CITY OF MERCER ISLAND, WASHINGTON

February 13, 2015

RE: Notice of Incomplete Application for File No. CAO15-001 at 5637 East Mercer Way, Parcel 1924059312

BOUNDARY / TOPOGRAPHIC SURVEY No. Data Bl./Col.	1 1
	1 1
CHS ENGINEERS, LLC 5637 EAST MERCER WAY MERCER ISLAND, WA TEL: (425) 877-9699 FAX: (425) 877-9384 WWW.CHSENGR.COM DATE: 11-14	SUMMERS DEVELOPMENT SHEET 1 OF 1 JOB NO. 001411

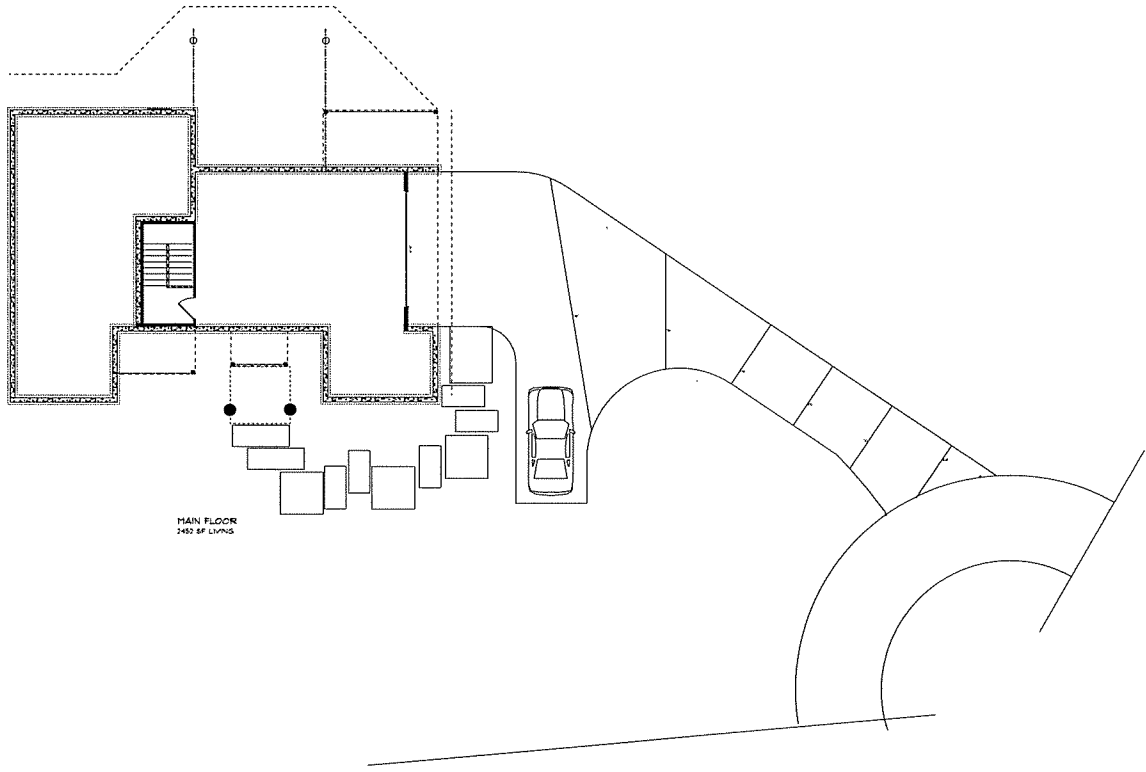
- ✓ Property boundary lines
- ☐ Building setbacks/yards – *Please show setbacks on the proposed site plan (CHS Engineers Sheet 1 of 1). Please see 19.02.020(C).*

- ✓ Existing structures
 - ☐ Proposed structures – *The storm detention vault is described as being located within the driveway. The site plan shows the storm detention vault partially within the driveway, partially outside the driveway. Please resolve this discrepancy. Please also indicate point of discharge as well as the location of other utilities. Additionally, please show all proposed structures on all applicable documents, including the critical areas study;*

- ☐ Existing Critical Areas (i.e. wetland boundaries, OHWM of watercourses) – *The site plan does not clearly delineate the critical areas and their associated buffers. Please clearly label.*

- ☐ "Standard Buffers" for wetlands and watercourses, as specified by MICC 19.07.070.A and 19.07.080.C - *The site plan does not clearly delineate the critical areas and their associated buffers. Please clearly label.*

- ☐ Proposed alterations of Critical Areas – *Please clearly define extent of disturbance, which includes any proposed clearing and grading.*
- ✓ Adjacent streets

- ☐ Drawn to scale – *Measurement of the site plan using the stated scale of 1"=20' indicates that the site plan is distorted, likely a printing error. Please provide a site plan that is correct to the stated scale.*

- A. Site survey – *The survey/site plan (CHS Engineers, page 1 of 1) does not contain a surveyor seal or signature, and as such, is not considered a survey. Please provide a current survey that is sealed and signed by a licensed professional land surveyor. The survey needs to delineate critical areas, pursuant to 19.07.050.*

The document does not contain a surveyor seal or signature, and as such, is not considered a survey. Please provide a current survey that is sealed and signed by a licensed professional land surveyor. The document was provided on an 8.5"x11" sheet, which is not to scale, and is illegible for review purposes. Please provide a to-scale document that is legible, preferably on an 18"x24" or larger sheet.
